## **APPLICANT'S COMMENTS ON THE REPORT ON THE IMPLICATIONS FOR EUROPEAN SITES (RIES)**

### **HyNet Carbon Dioxide Pipeline DCO**

Document Reference Number D.7.54

**PINS Reference:** EN070007

DRAWING TITLE
 Figure 19.1 Other Developments Sheet 1 of 3

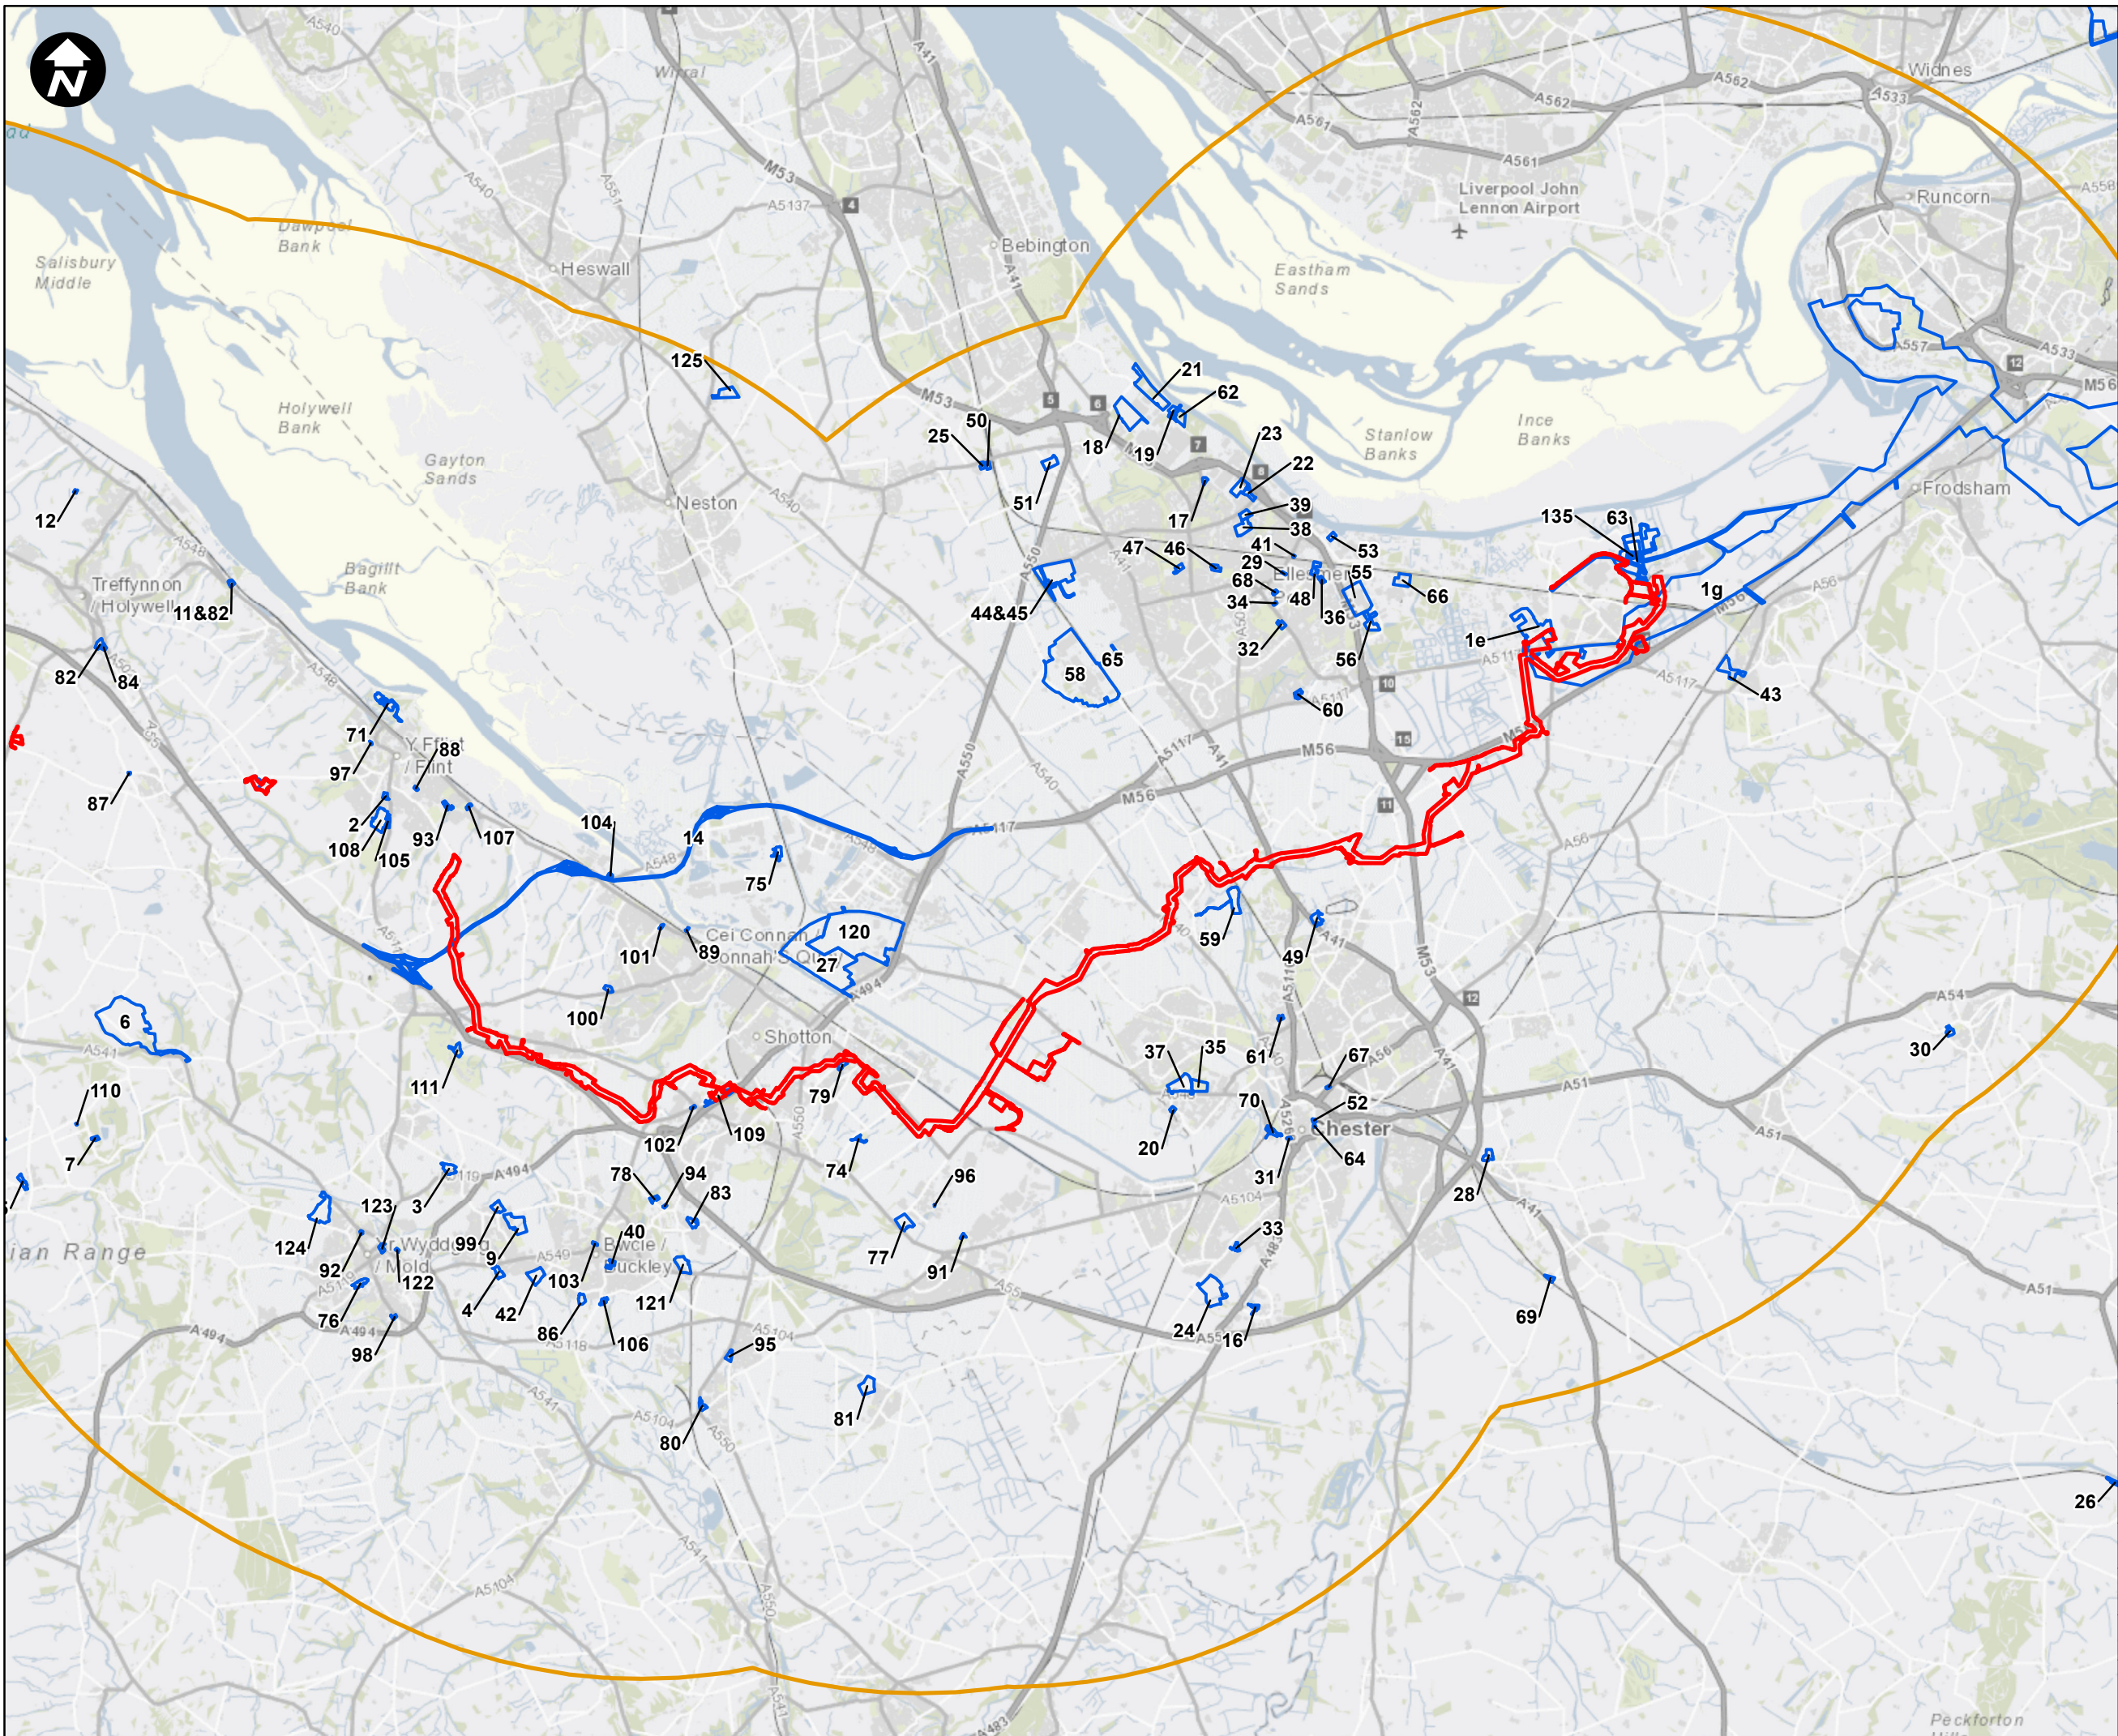
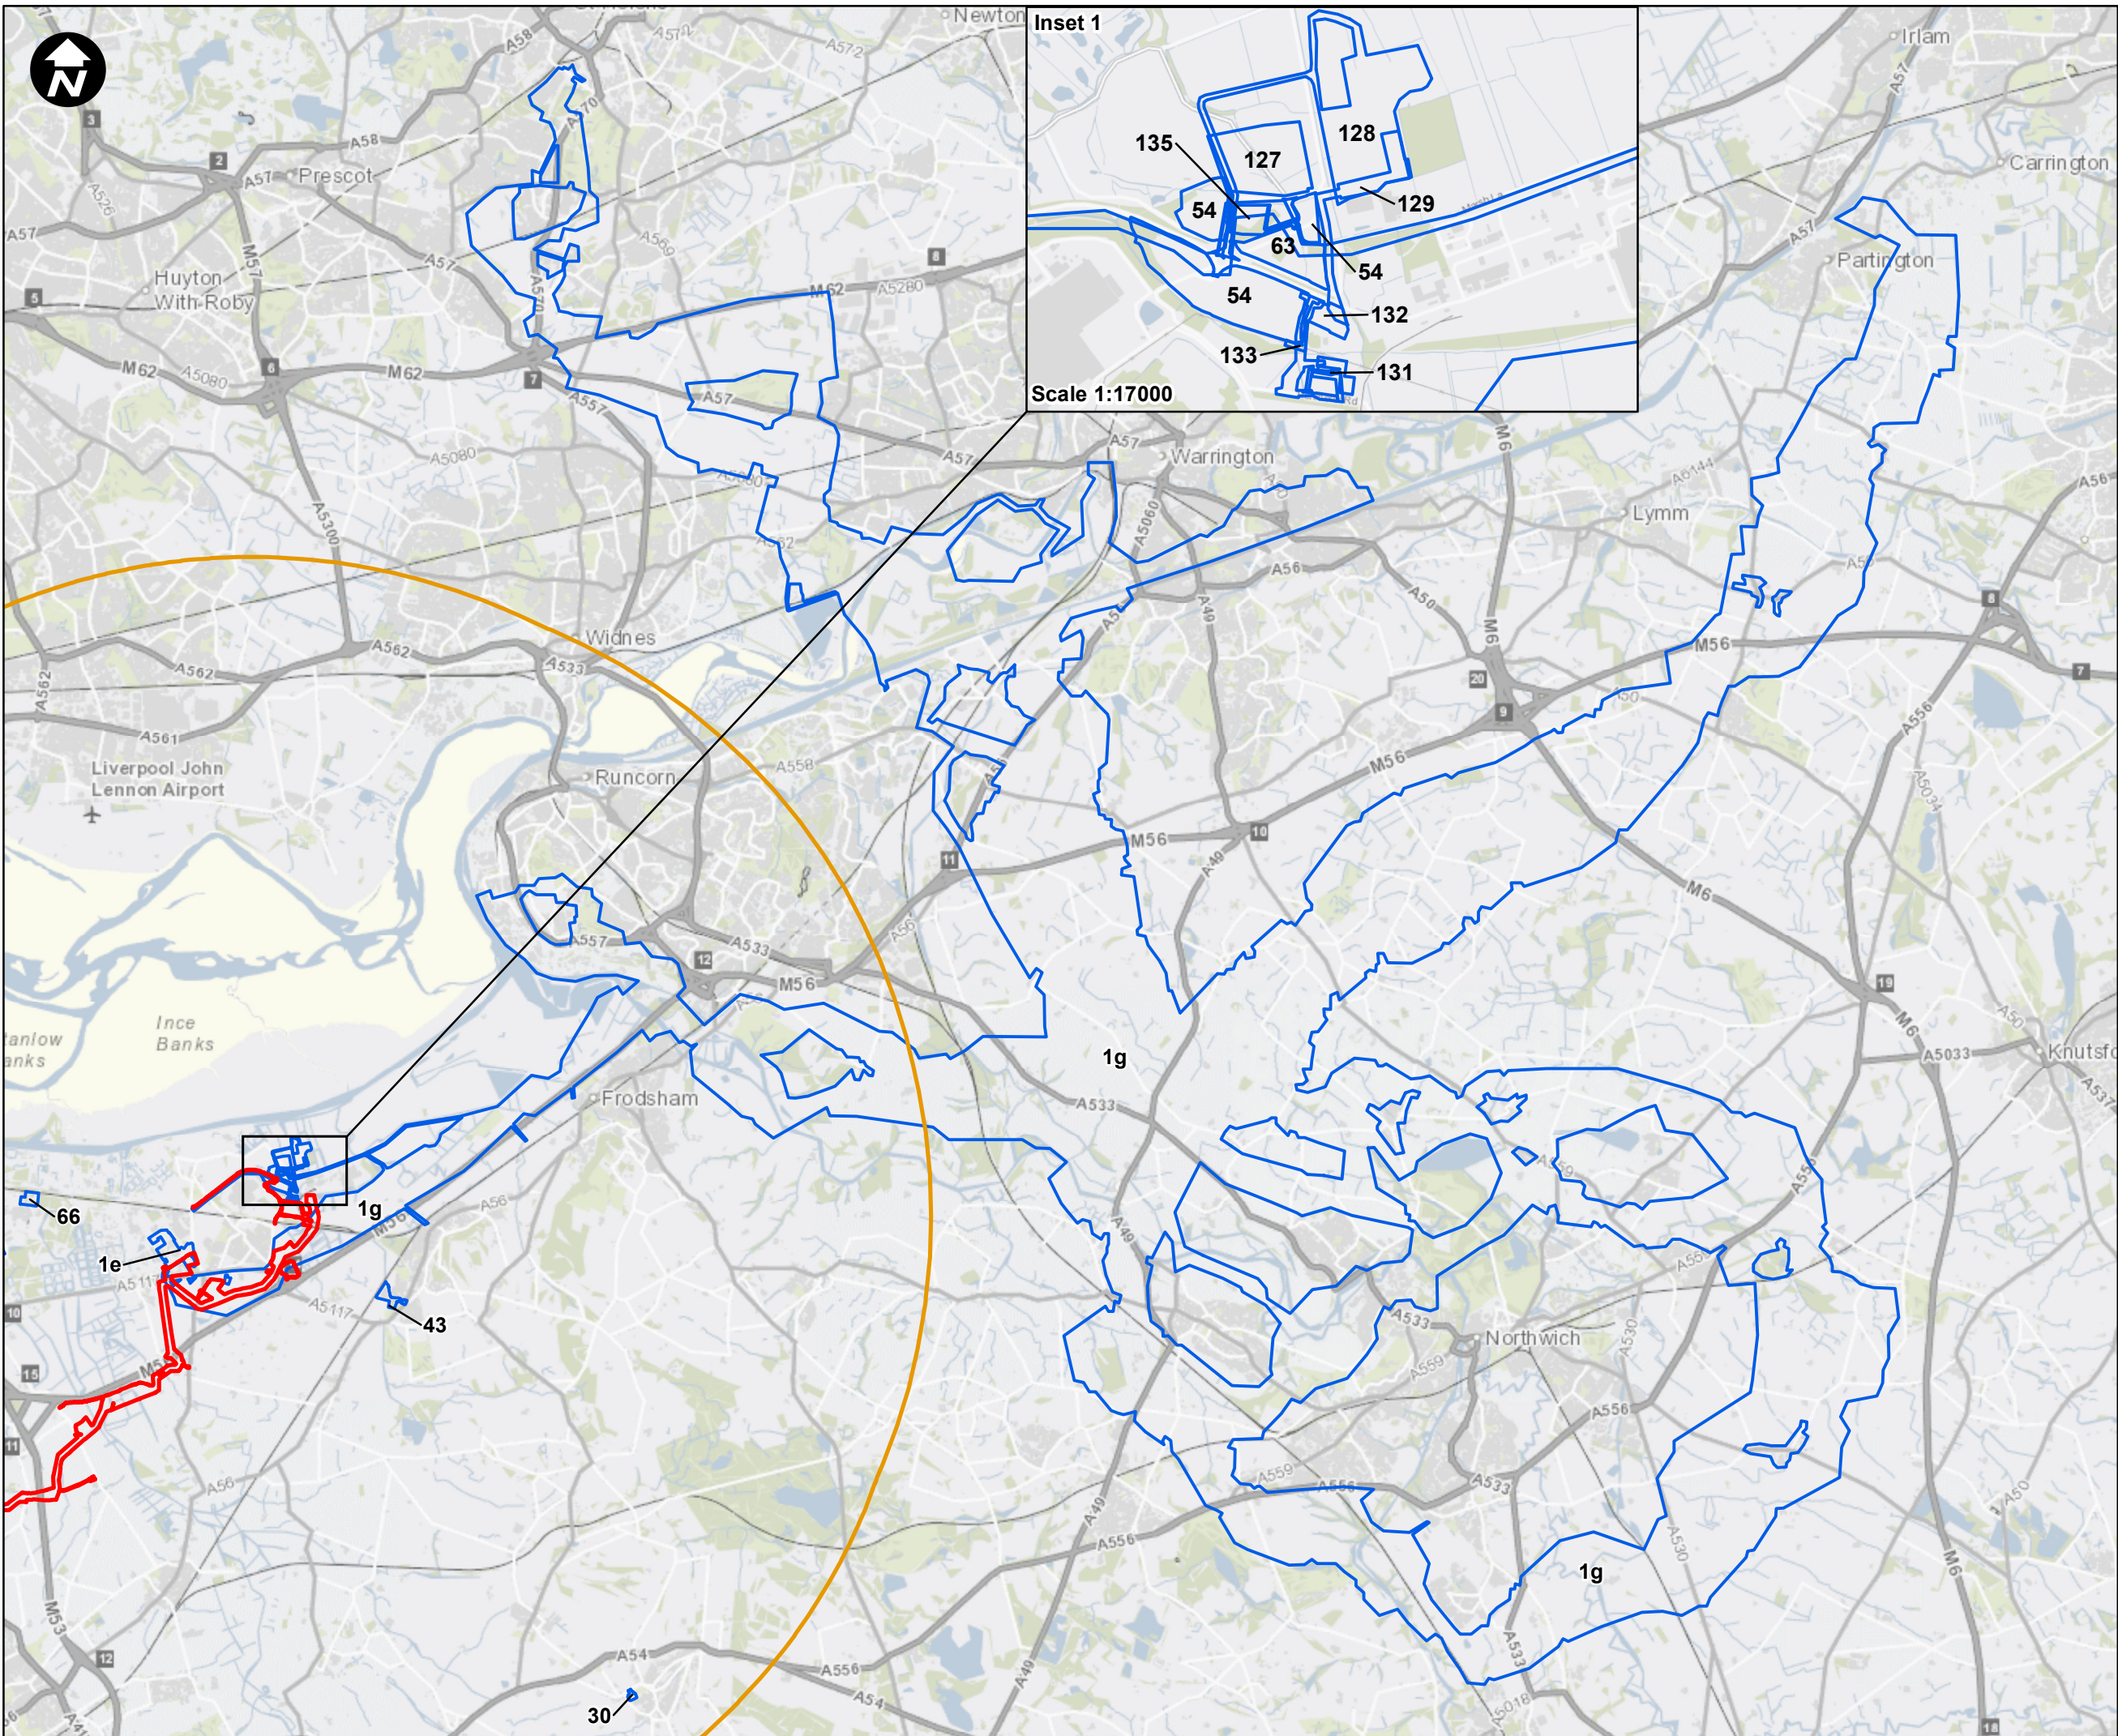
Applicant Reference	RIES Reference	ExA Query / Applicant’s Clarifications	Applicant Response
1	Paragraph 2.1.3 and Table 2.1	Applicant’s Clarification / suggested amendment to REIS	The Applicant would like to clarify that the distances cited within the ‘Distance from Proposed Development’ column of Table 2.1 in the RIES [OD-008], match that of the Habitats Regulations Assessment (HRA) submitted at Deadline 4 [REP4-243] and not that of the HRA submitted with the DCO application [APP-226] as alluded to within paragraph 2.1.3 in the RIES [OD-008]. It is therefore suggested that paragraph 2.1.3 should be updated to reference [REP4-243].
2	Paragraph 2.3.1	Applicant’s Clarification / suggested amendment to REIS	The Applicant would like to clarify that as per paragraph 6.4.1 of the HRA [REP4-243], Appendix B of the document listed 41 ‘Other Developments’, not 42 as stated within the RIES [OD-008]. The Applicant can confirm that additional ‘Other Developments’ have been included for consideration as part of the in-combination assessment within the HRA [REP4-243] submitted at Deadline 7. It is therefore suggested that paragraph 2.3.1 should be updated to state 41 ‘Other Developments’.
